**From:** [REDACTED]  
**To:** [Norfolk Boreas](#)  
**Subject:** Boreas Project in lieu of attendance at hearing 3, deadline 4. EN10087  
**Date:** 22 January 2020 15:37:17

**From:** [REDACTED]  
**To:** [Norfolk Boreas](#)  
**Subject:** Norfolk Boreas Project EN10087.  
**Date:** 30 January 2020 18:16:28

Title:	Scenario 1 Viewpoint 3: Lodge Lane North
--------	--

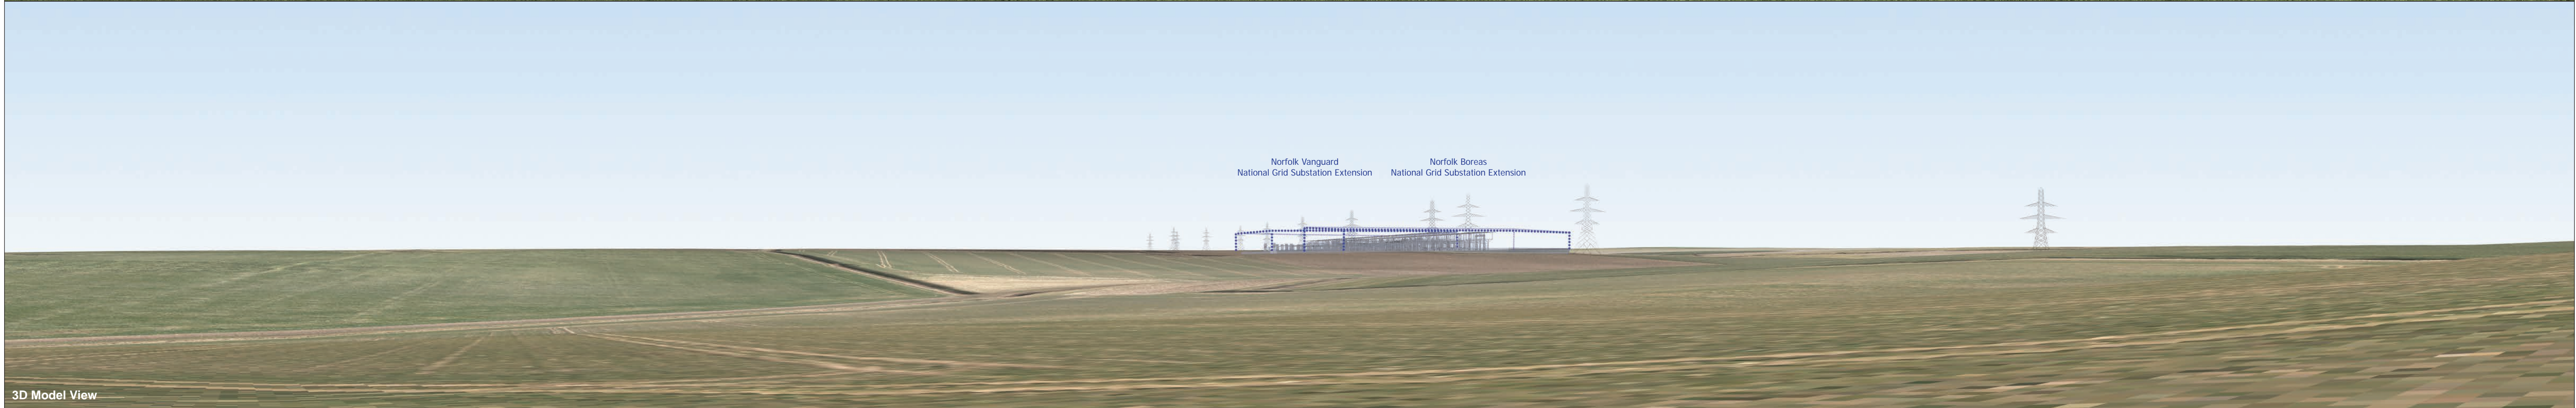
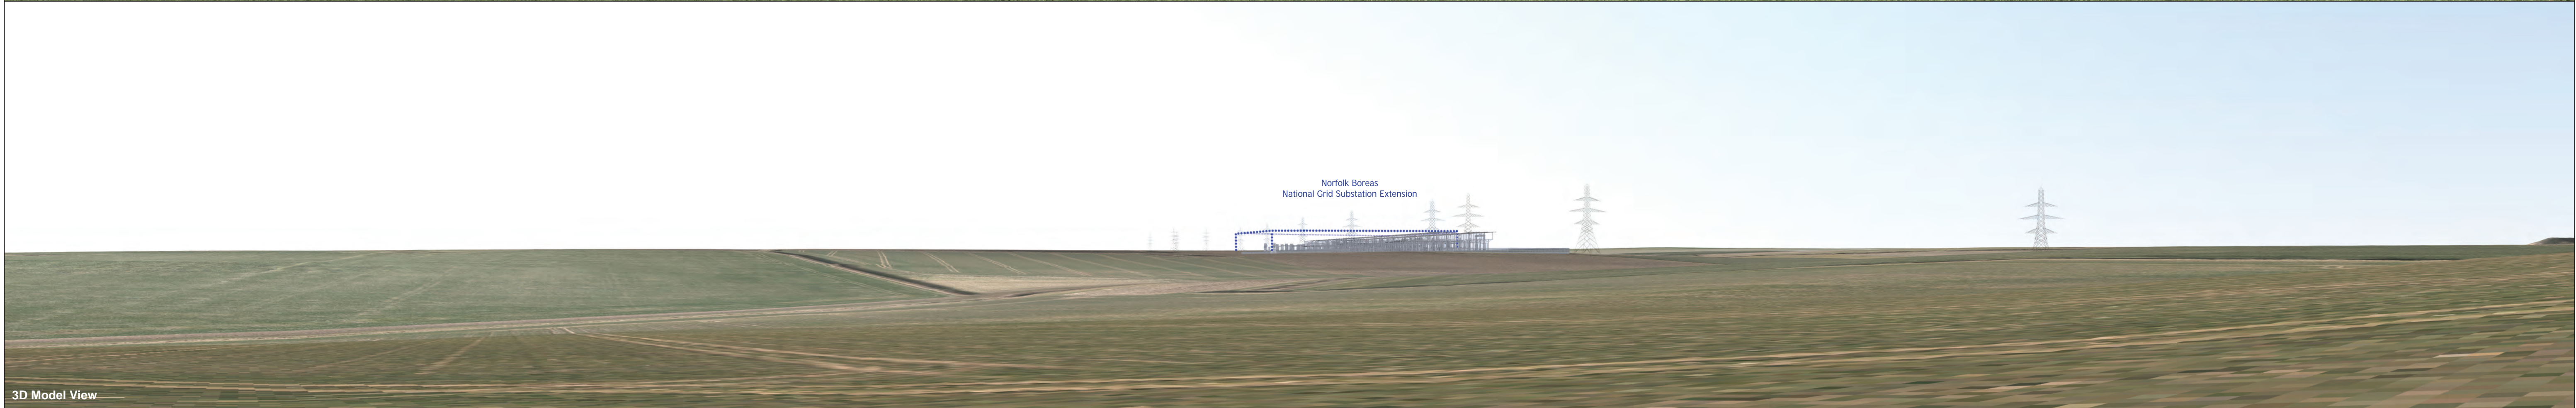
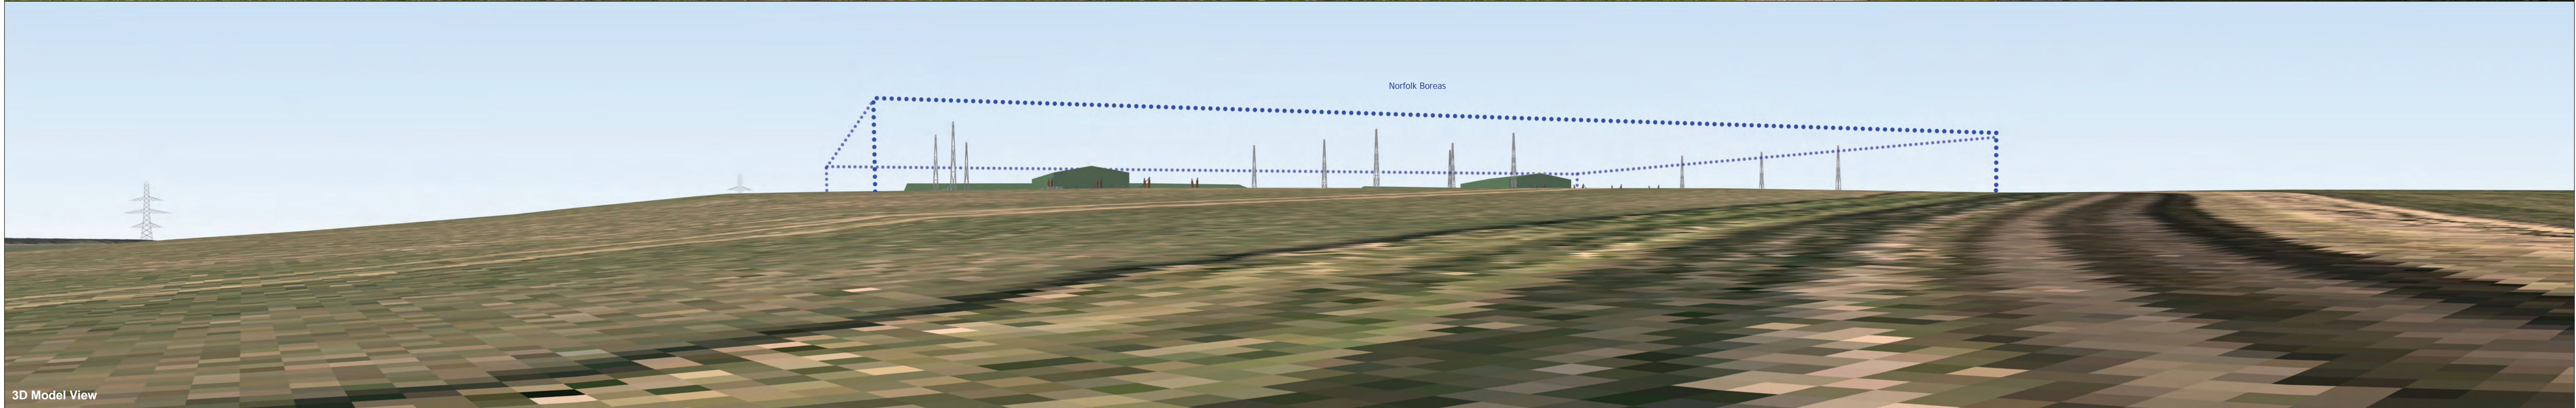
I have to disagree with the applicants response to my observation, that the photo montages at Lodge Lane North are flawed. The applicant suggests they do not know whether the the rise in landform to the fore of the onshore project substation actually occurs or not, and it cannot be determined from the baseline photograph, as the mature woodland associated with Lodge Farm screens this portion of the view. Using Google Earth Pro, ground levels through Lodge Farm trees shows that the land continues to gently fall to the west, away from the lane, as it does all the the way along the lane, up to Lodge Farm. I have also walked the area and I can confirm this, with no concealed ridgeline. I disagree with the applicants opinion, that the more critical point in terms of screening is the extent to which the landform falls away to the south. I agree the land falls approximately 5m from Lodge Farm to the viewpoint, but the land continues to rise a further 3m beyond Lodge Farm, to the converter halls. With the comparable distance from the viewpoint to Lodge Farm, and from lodge farm to the converter halls, the further 3m rise behind Lodge Farm negates most of this critical screening effect, and yet the photo montages show the converter halls with a 17-18m screening effect. I have included a scale side elevation diagram of viewpoint 3 to demonstrate the situation, and it shows the converter halls in full view. As the ground continues to fall at a similar gradient to Lodge Lane South viewpoint 2, from viewpoint 3, the same issue applies, and the converter halls will be far more visible than shown in the montage.

The only explanation for these discrepancies in my opinion is, the OS 5m DTM software used has an accuracy of +/- 2.5m rural, and less accurate where trees and buildings cover the terrain. The aforementioned mature woodland associated with Lodge Farm, has the capacity to cause a ridgeline great enough to cause the effect we are seeing at viewpoints 2 and 3 Lodge Lane, and the +/- 2.5m accuracy over the distance involved with viewpoint 7 could be enough to produce the photo montage in question. Working with the limitations of this accuracy on a project of this size it could be suggested that an on foot survey should be carried out to check for obvious anomalies, but I do not consider this to be a satisfactory solution, capable of producing images accurate enough, to be used to plan successful mitigation, and to generate photo montages of successful mitigation to show residents, interested parties, and the planning inspectorate. A more accurate system is needed for a cumulative project of this size, where the distances involved are so large from the project to viewpoints, a 5m inaccuracy in the height of a mitigating screen, natural or not could make the photo montage virtually useless.

I strongly feel that if we are expected to accept this not insignificant construction, and live with it, we could be afforded more reliable positive mitigation, that is not based on the above method. Earth bunding was mentioned early on in the Vanguard, Boreas consultation as a possibility. It would massively help the visual mitigation, and also prove beneficial to the noise mitigating measures.
